16 August 2021

NL191366.B14

Re: John Hunter Health and Innovation Precinct – Civil Updates following SSDA Submission

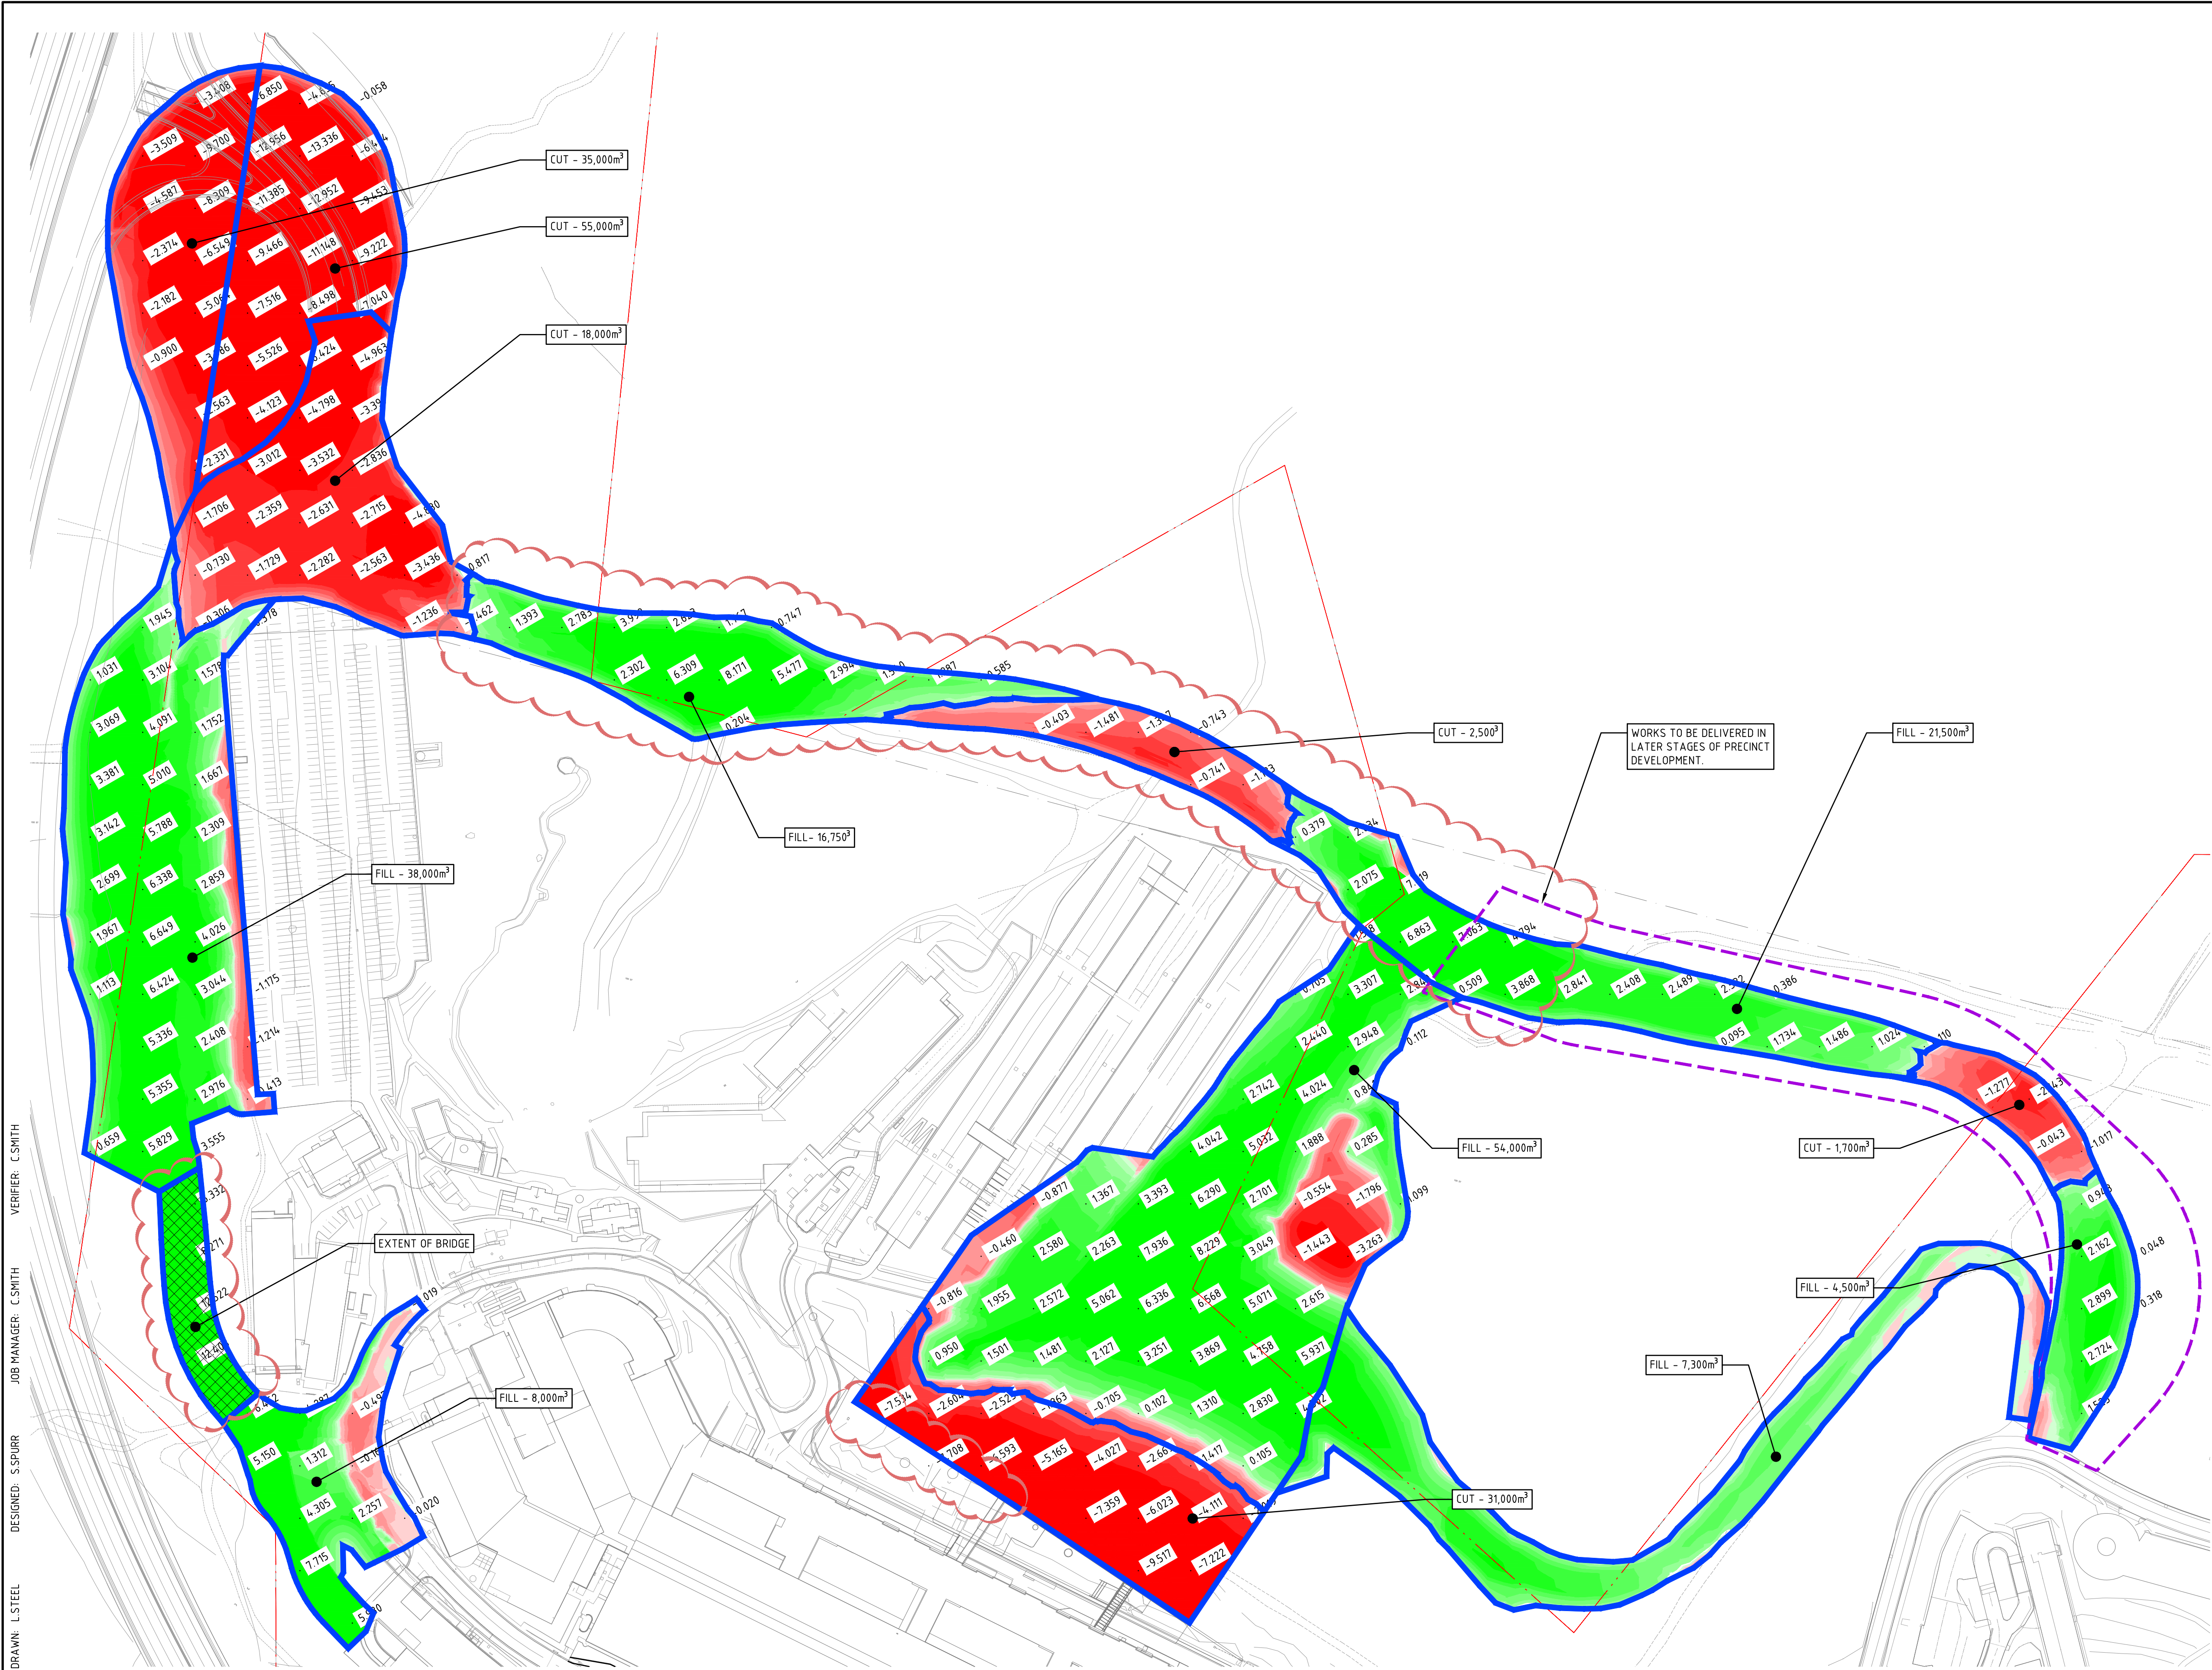
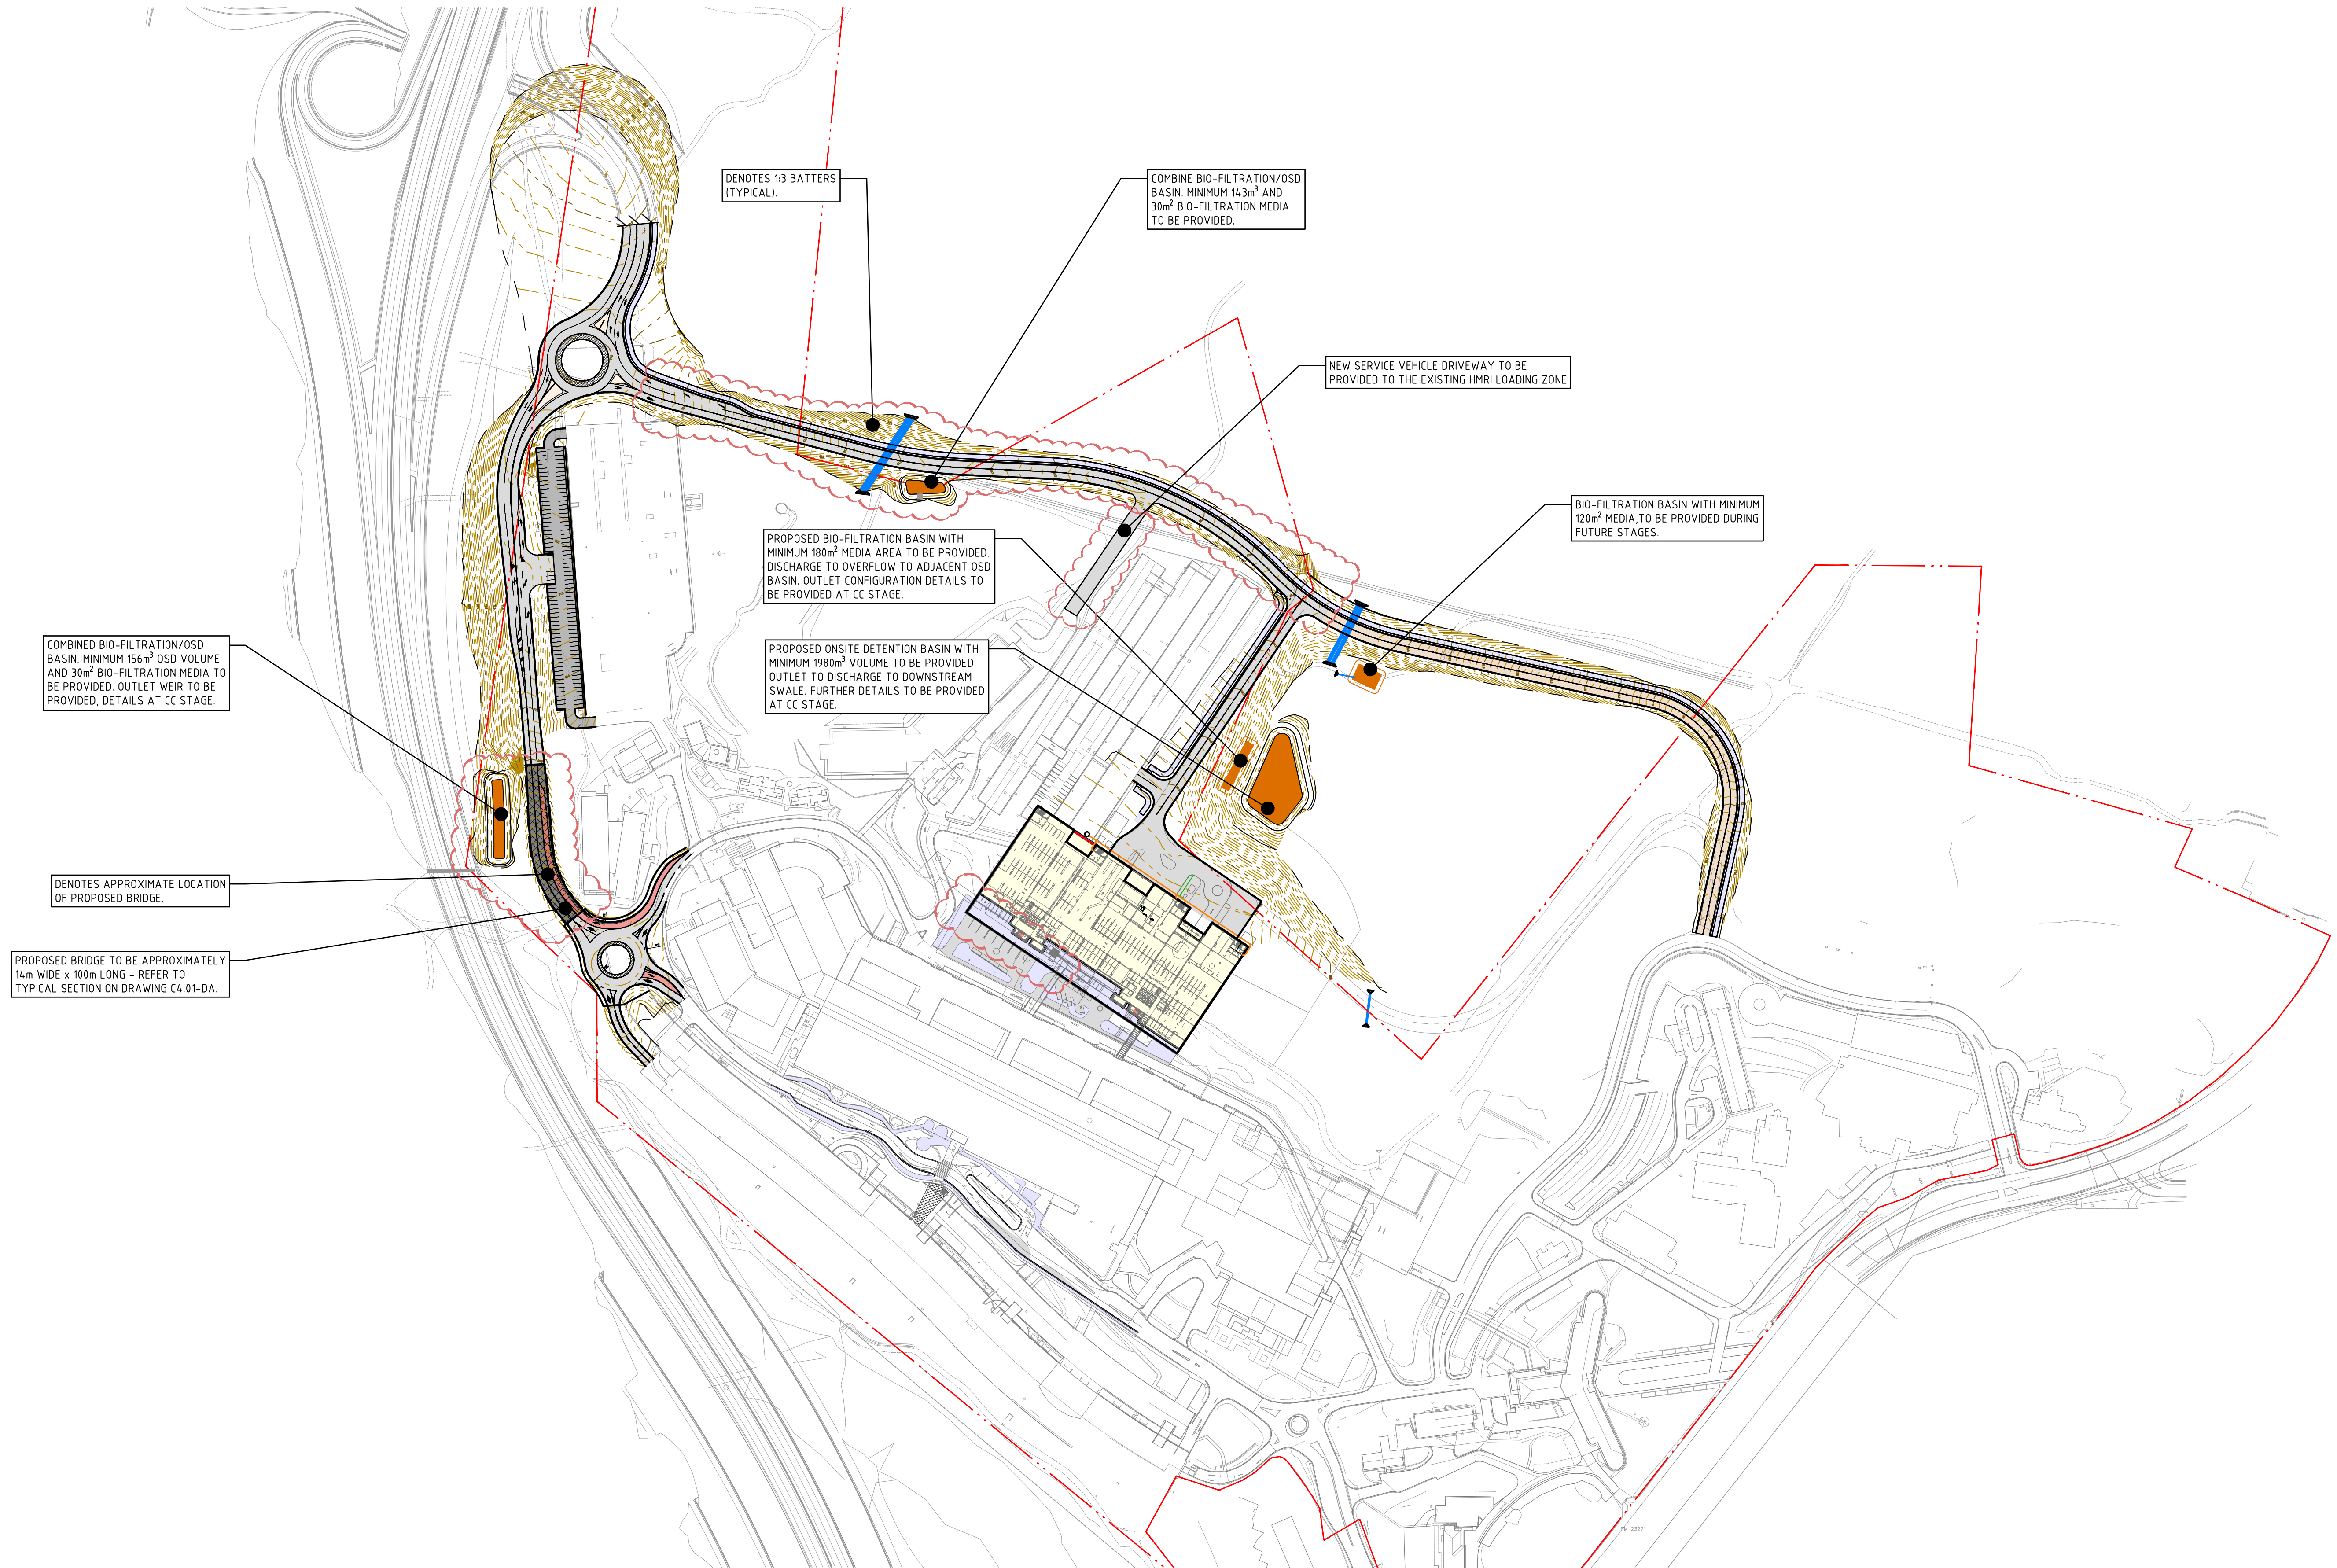
- The B4 carpark level to the proposed Acute Services Building (ASB) has been lowered by approximately 1m to improve carpark efficiency and clearances to building services. Spatially the civil design is unchanged by this modification, however bulk cut and fill volumes have been modified to reflect a reduction in fill and increase in cut for the carpark and associated driveway. – refer to drawing NL191366, sheet C200-DA for updated cut and fill quantities.

- Modification of associated cut and fill volumes, refer to amended bulk earthworks plan NL191366, sheet C200-DA for details. We note that the earthworks methodology is generally unchanged with regard to embankments and cut/fill zones, the details have simply been amended to reflect the modified road alignment.

- Minor realignment of north road intersection with Jacaranda Drive to improve driver sight lines.
- Lowering of the ASB driveway to match the revised north road and ASB levels which subsequently modified the associated bulk earthworks quantities – refer to NL191366, sheet C200-DA for details.
